## **REVISION RESPONSE LETTER**

**RE: Claremont Business Park 2 Filing 1, Lot 1  
Site Development Plan  
File Number PPR2034**

**DATE:** February 5, 2021

GRADING & EROSION CONTROL PLAN
 CLAREMONT BUSINESS PARK 2 FIL. NO. 1 - LOT 1
 JOB NO. 44-037
 DATE PREPARED: SEPT 04, 2020
 DATE REVISED: JANUARY 21, 2021

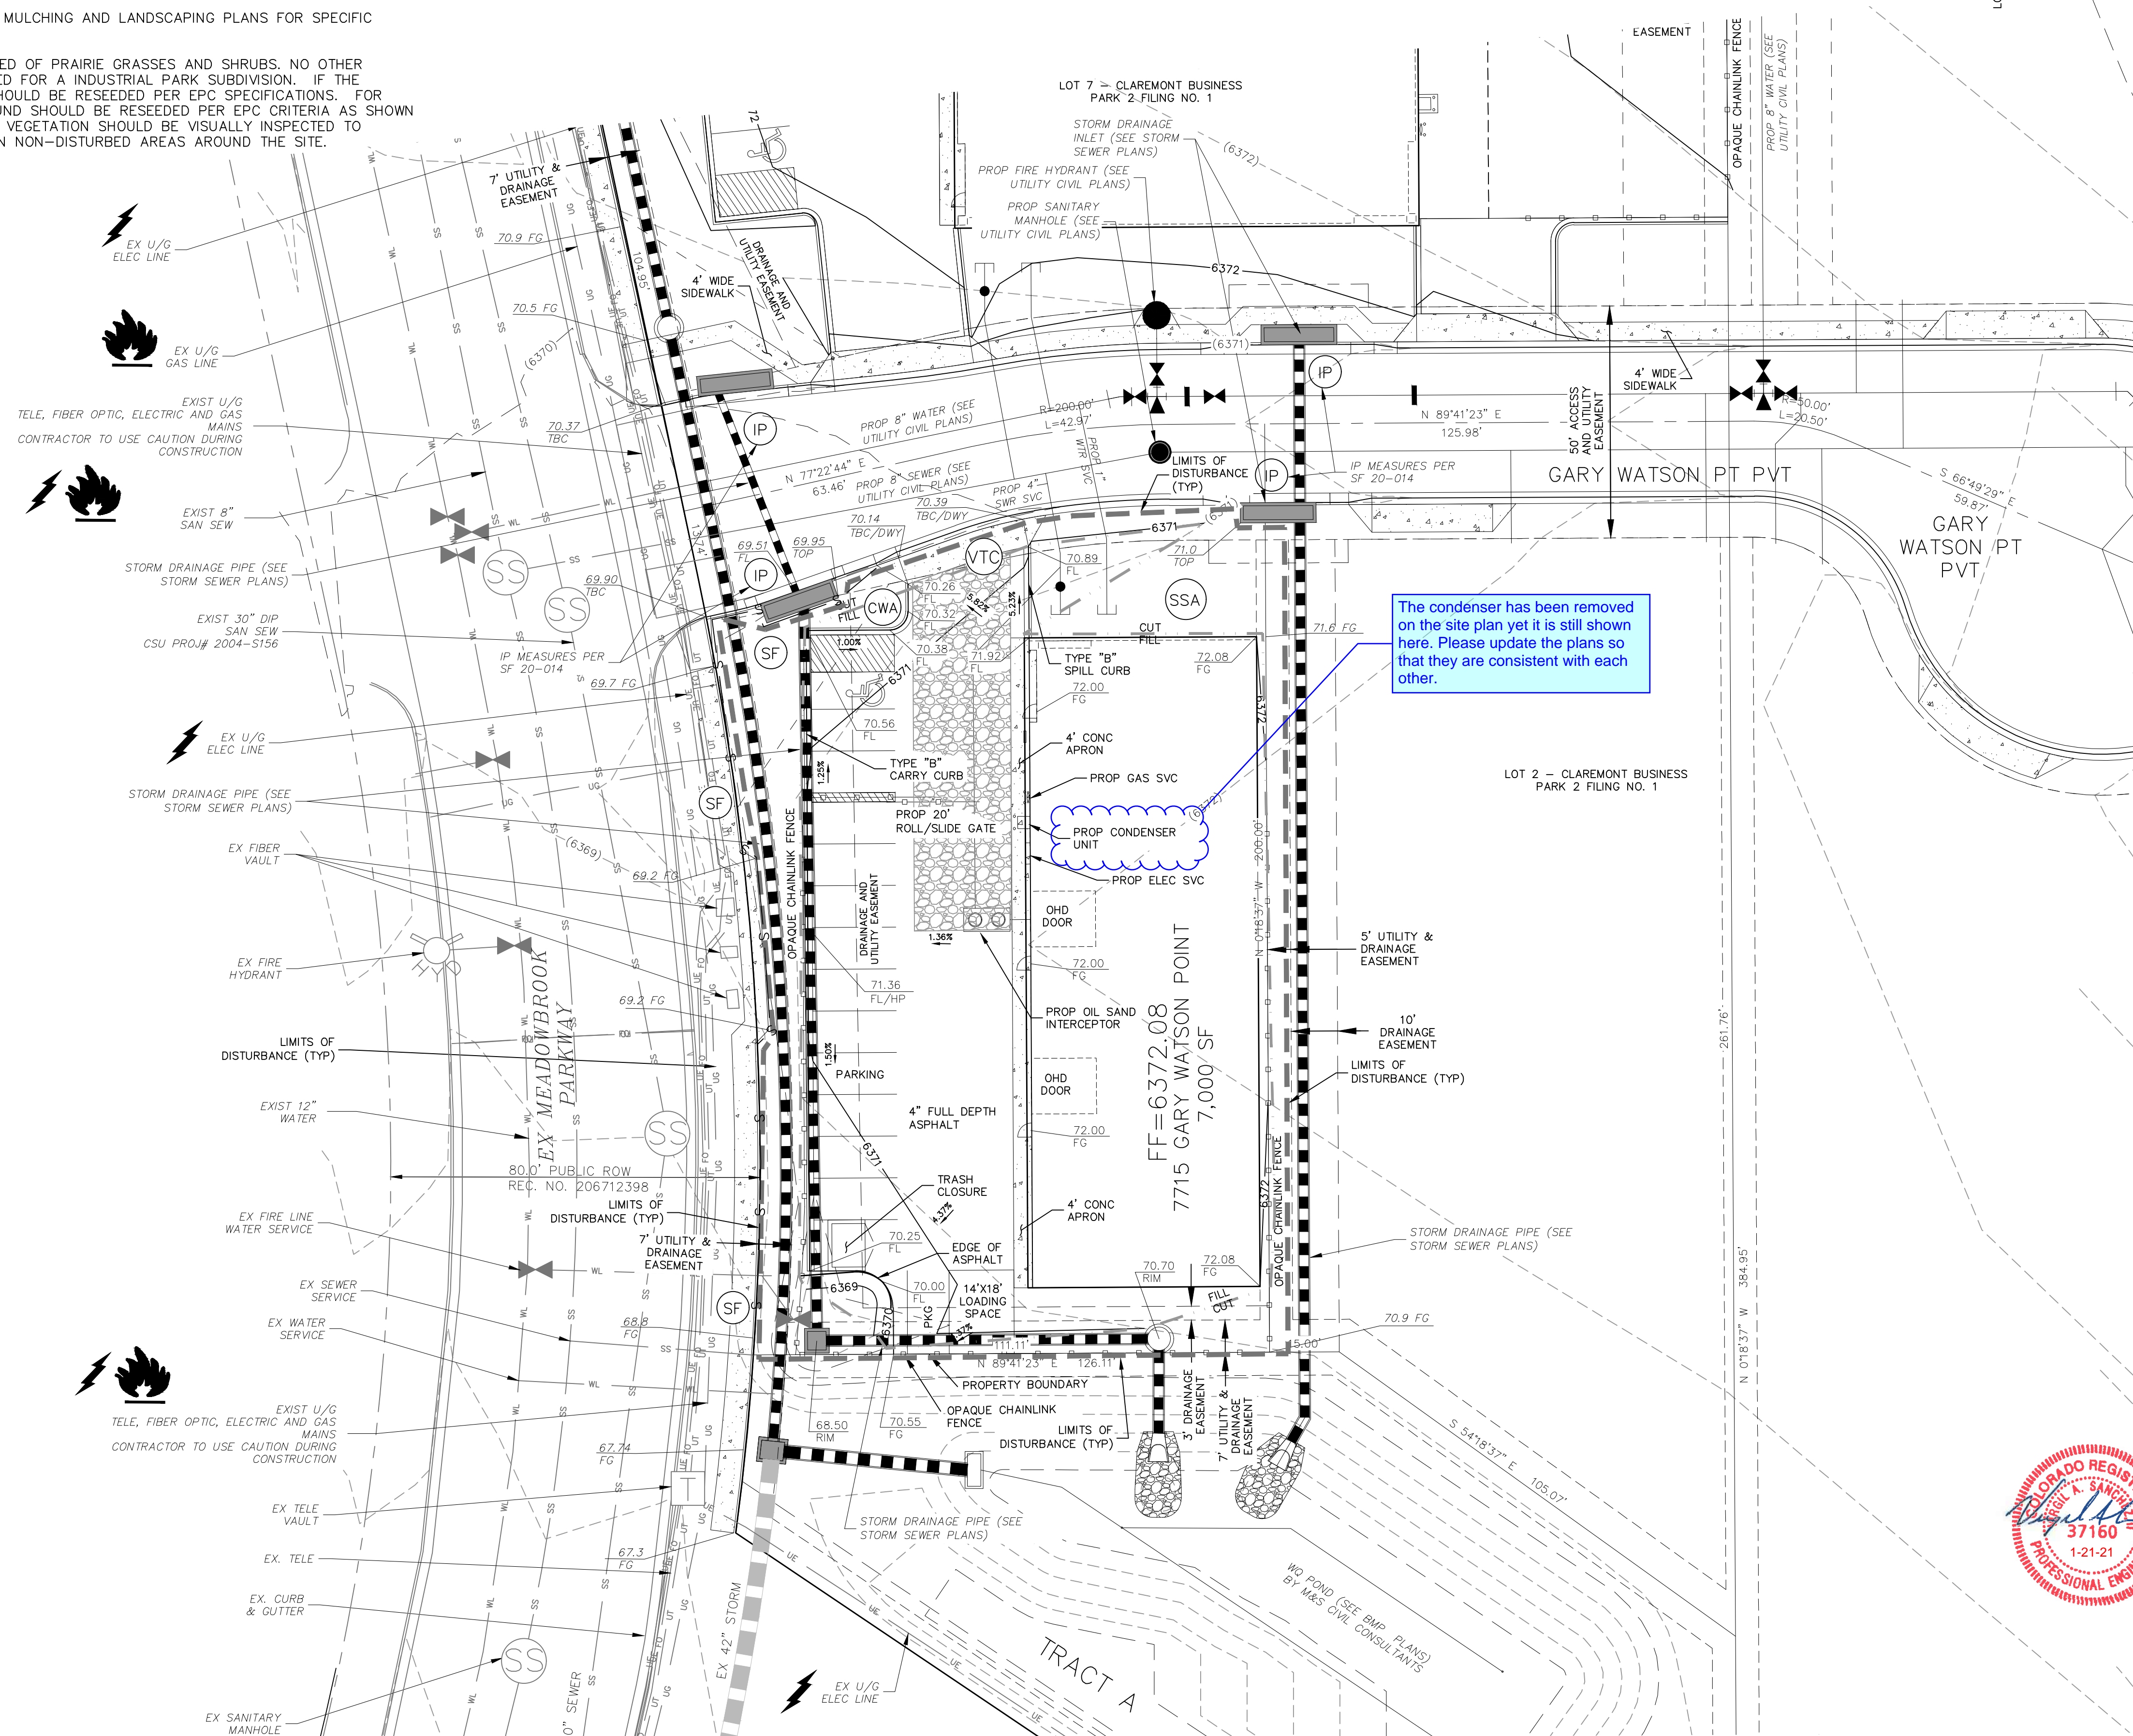
1. *Show existing and proposed topography.* Existing and proposed topography is shown on the Grading & Erosion Control Plan from M&S Civil Consultants, Inc., included in the original submission of this Site Development package. Per the Planning and Development website, “A Site Plan is an accurately scaled drawing of a lot or parcel showing, at a minimum, the property address, the schedule/tax number, all existing structures, easements, rights-of-way, setbacks from the property lines to the existing structures (if any), the location of the lot in relation to abutting streets, driveway/access location(s), and dimensions of the proposed structure and of existing structures, including height.” We feel to clearly show the intent of our site layout, by keeping the plans as clean as possible to maintain the required information, the grading contours should remain off and shown on the grading plan as it is part of site development package. In addition, we try to ensure accuracy, and not be held liable, by not duplicating information that may not be carried over from outside sources, i.e., civil engineering plans. Furthermore, we have been doing plans in EPC for 20 years and this comment has never come up before. As mentioned above, we would prefer to keep the grading off of the site plan to maintain consistency, accuracy and cleanliness.
